File: SF17/38691
Job ID No: DOC17/524421
Your Ref: SSD8761

RE: Heritage Council comments on Walsh Bay Arts and Cultural Precinct (SSD 8671)

Reference is made to your correspondence received on 20 October 2017 inviting the Heritage Council of NSW (the Heritage Council) to provide comments on the Environmental Impact Statement (EIS) for the Walsh Bay Wharves Precinct project.

GANTRY STAIR A-01 GROUND PLAN
1:50

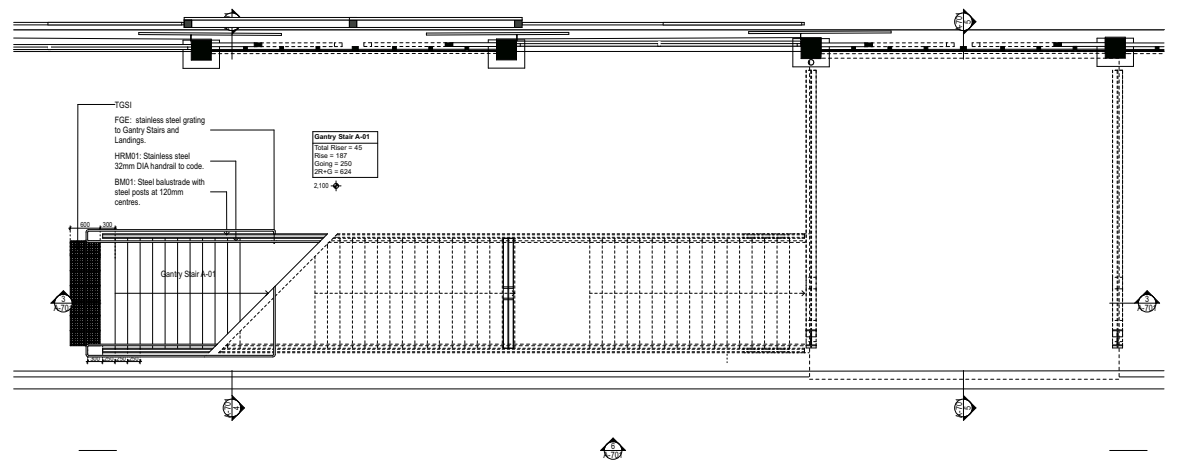
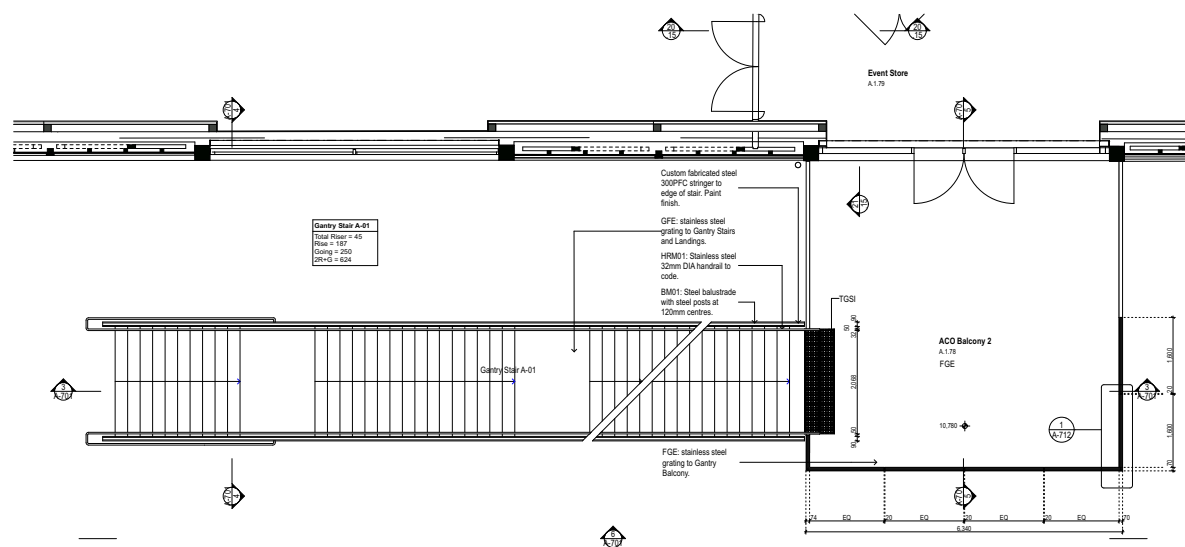
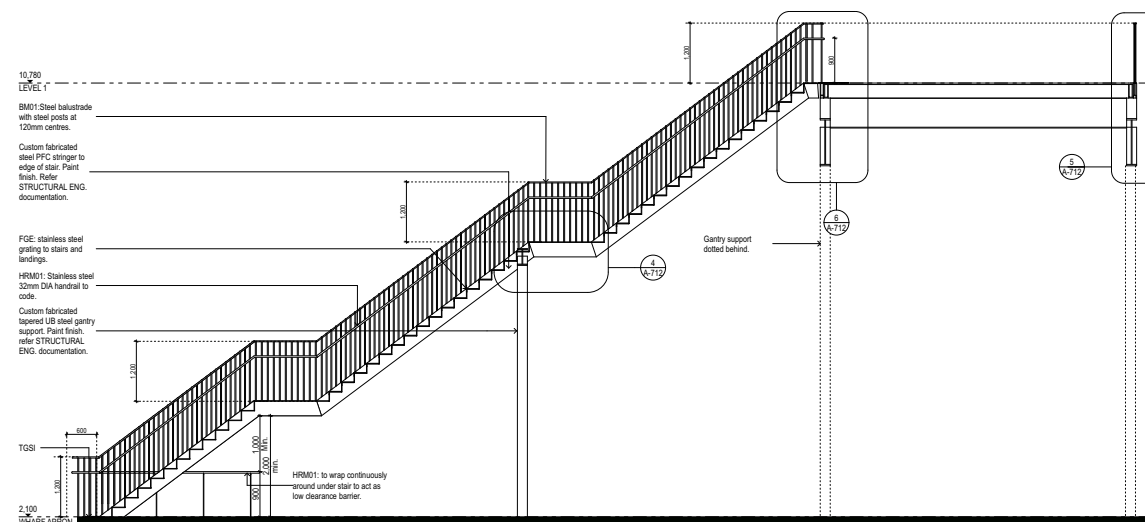
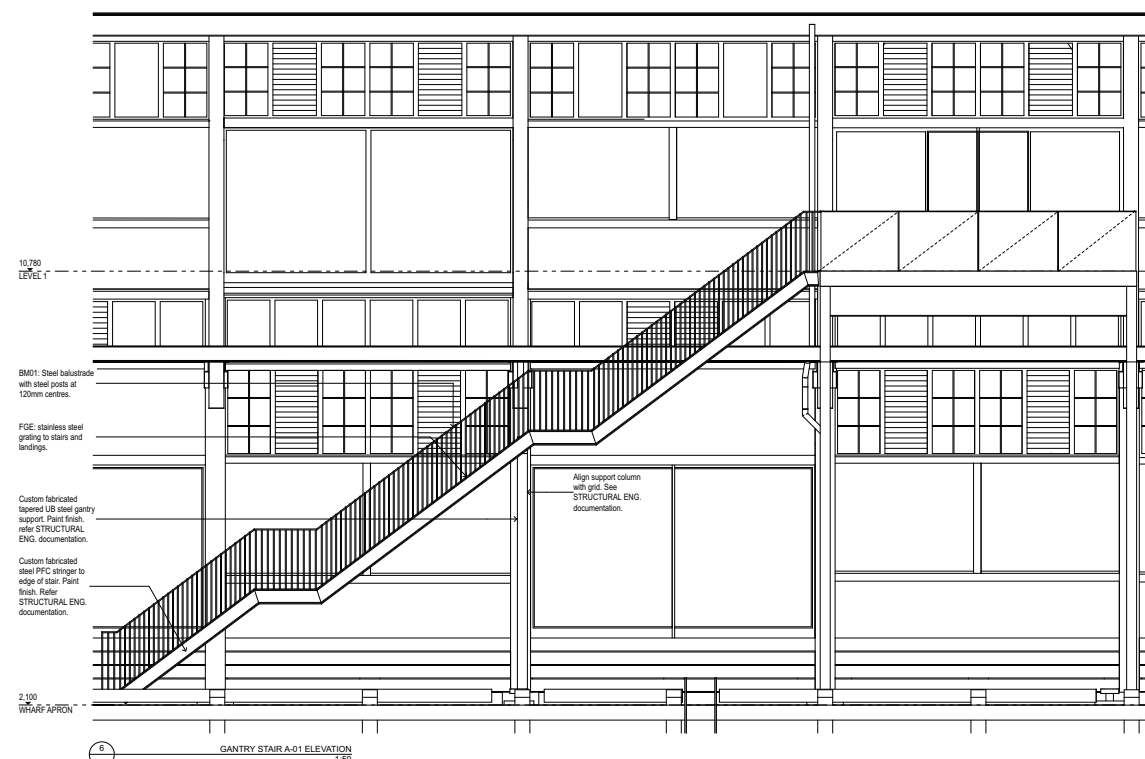
- j) It is unclear how proposed new external gantry/platforms features will be tied back to the wharf structure and if any additional strengthening of the wharf that is required. Further design details for these elements must be provided to the Heritage Council for assessment prior to approval of this project.
